David Gibson
Team Leader
Social Infrastructure Assessments
Department of Planning & Environment
GPO Box 39
Sydney NSW 2001

**Concord Repatriation General Hospital Redevelopment (Concept and Stage 1)
1H Hospital Road, Concord West (SSD 9036)
Notice of Exhibition**

TAB A – Detailed Comments on State Significant Application SSD 9036

Figure 5 – Site Plan

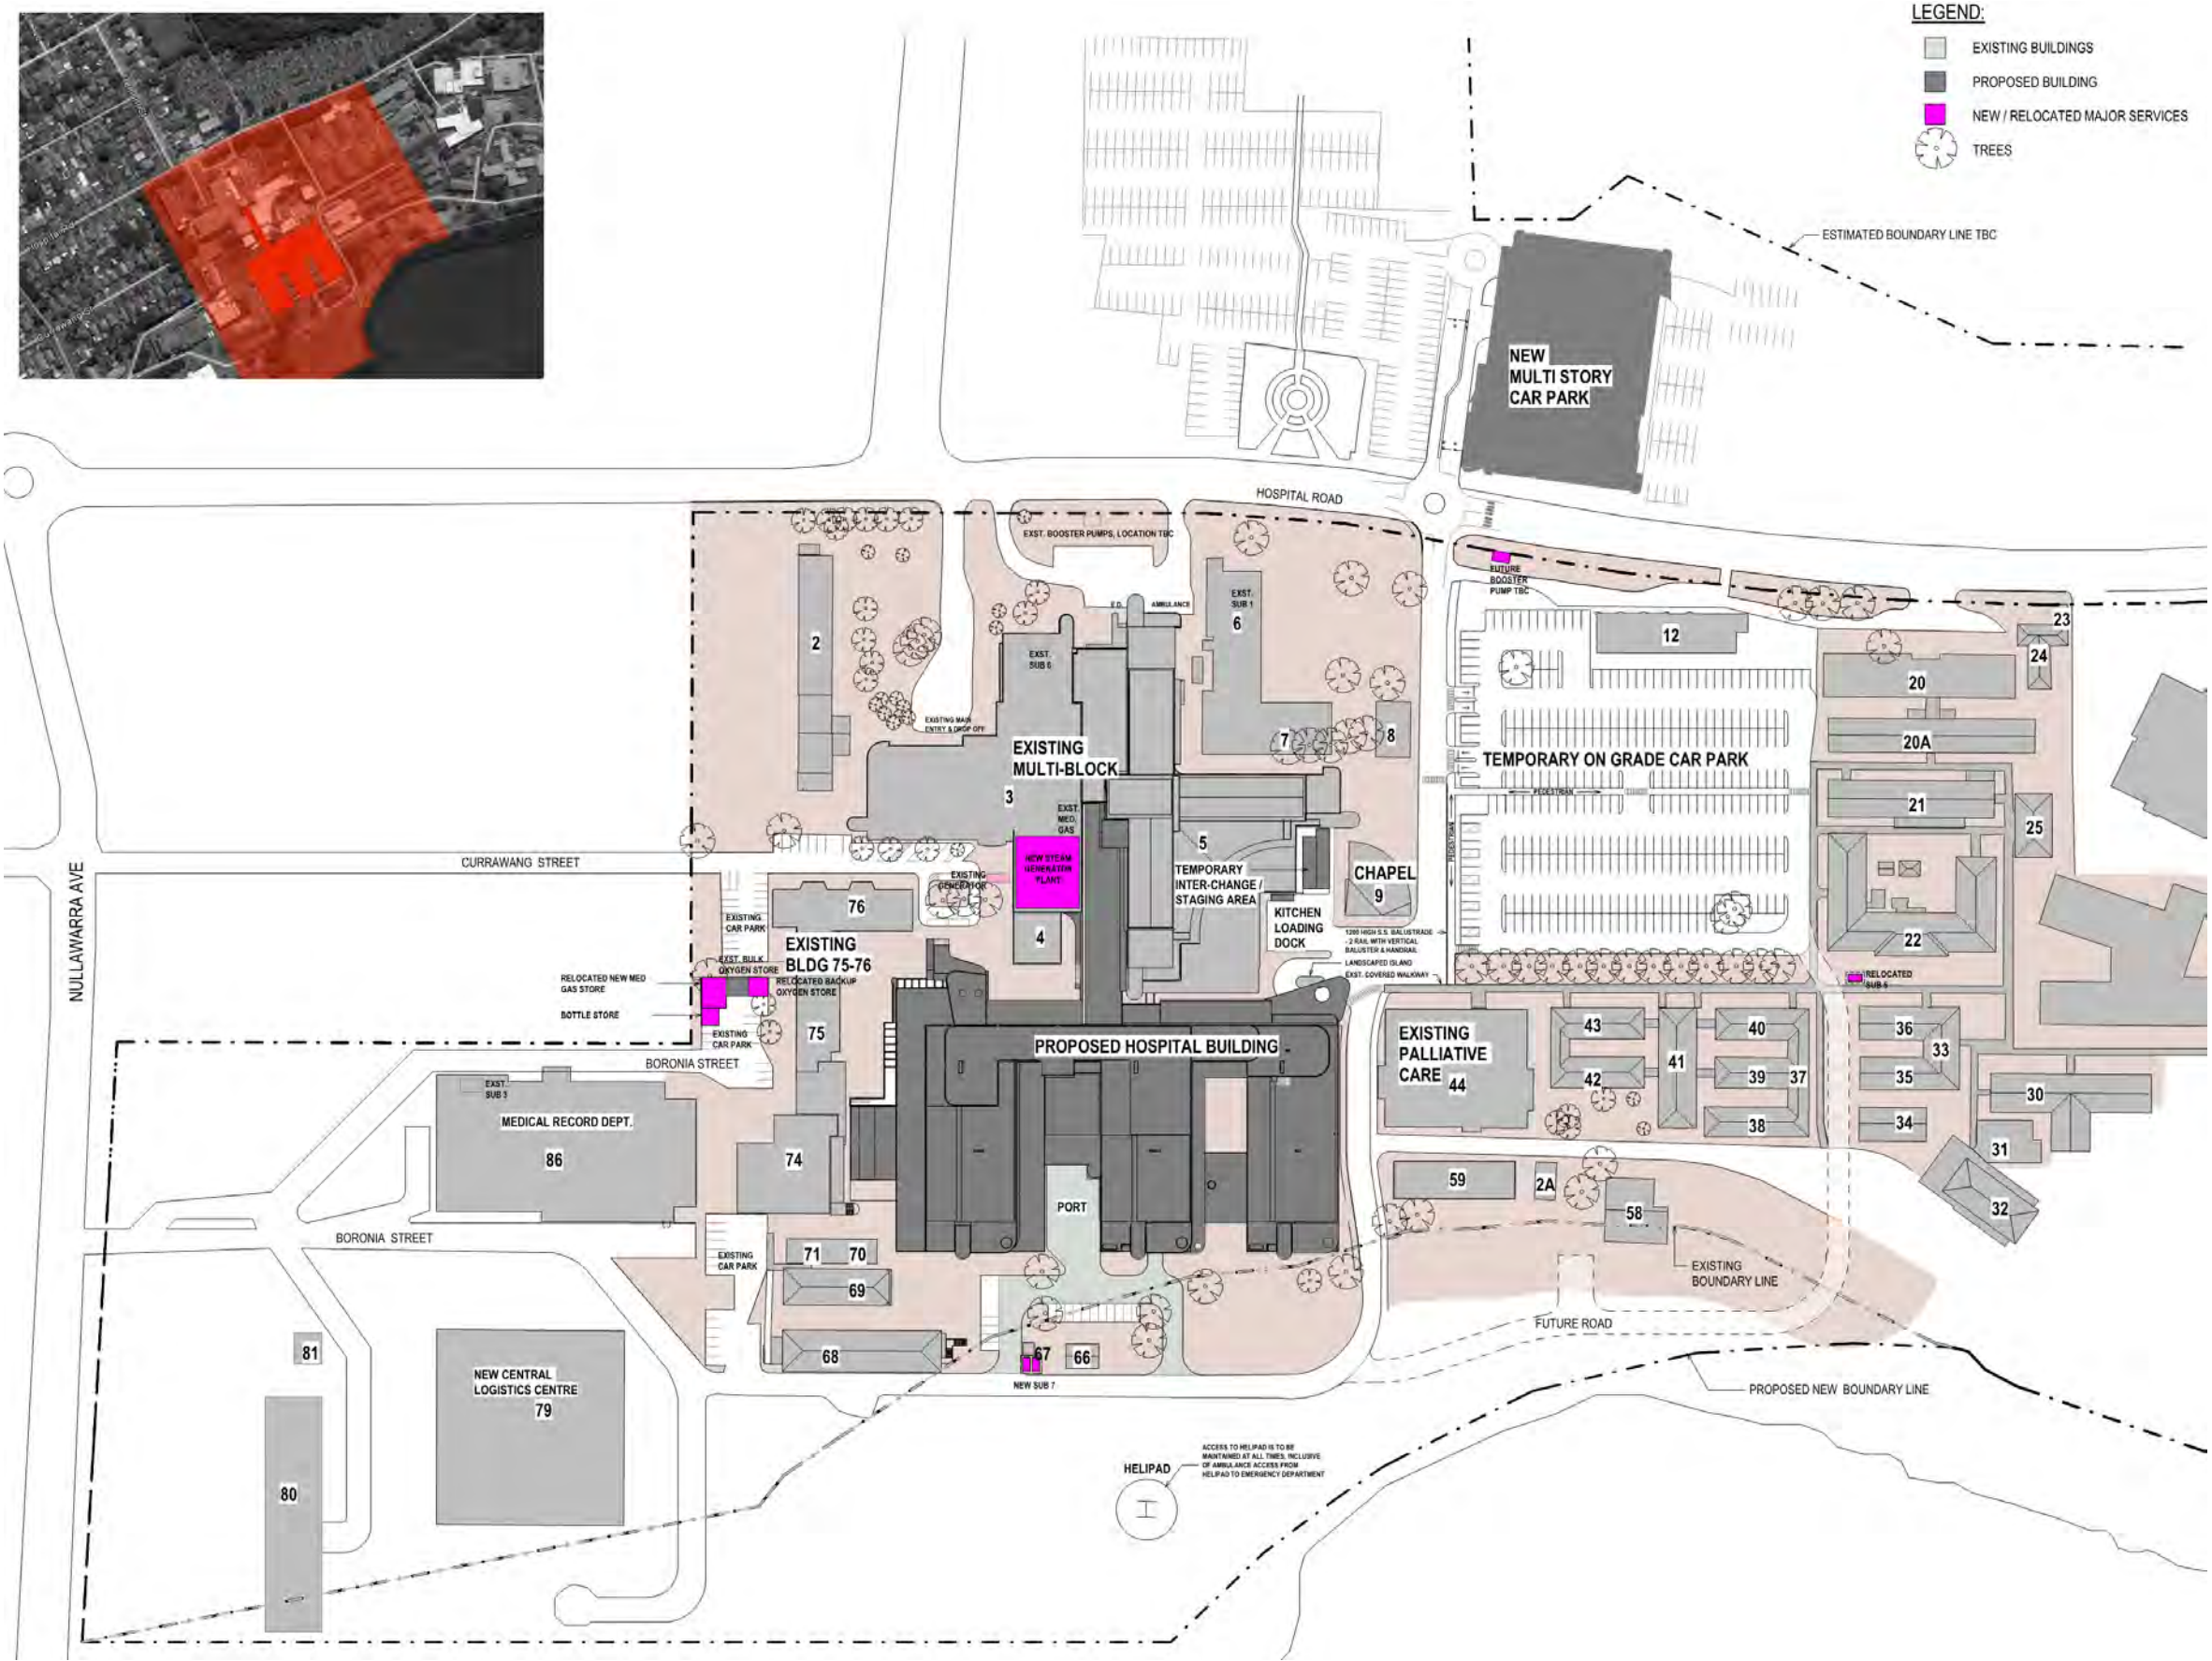
- The design of the two roundabouts provided in the Architectural Concept Plan in Appendix C suggests a two-lane approach to a single lane roundabout. The plans should be clarified and amended as necessary to ensure consistency with Austroads Guide to Road Design Part 4B: Roundabouts Section 4.3.3 (2015) which requires the number of circulating lanes from any particular approach must be equal or greater than the number of entry lanes on that approach.

The Stage 1 works include the construction of roundabouts to service the multi-storey car park and new at grade car park. The architectural plans provided in Appendix C of the Concept Proposal indicate a two-lane approach to a single circulating lane roundabout at the intersection of Hospital Road and within the car park. The proposed design is inconsistent with Austroads Guide to Road Design Part 4B: Roundabouts Section 4.3.3 (2015) which requires that the number of circulating lanes from any particular approach must be equal or greater than the number of entry lanes on that approach.

The design of the roundabouts should be revised accordingly.
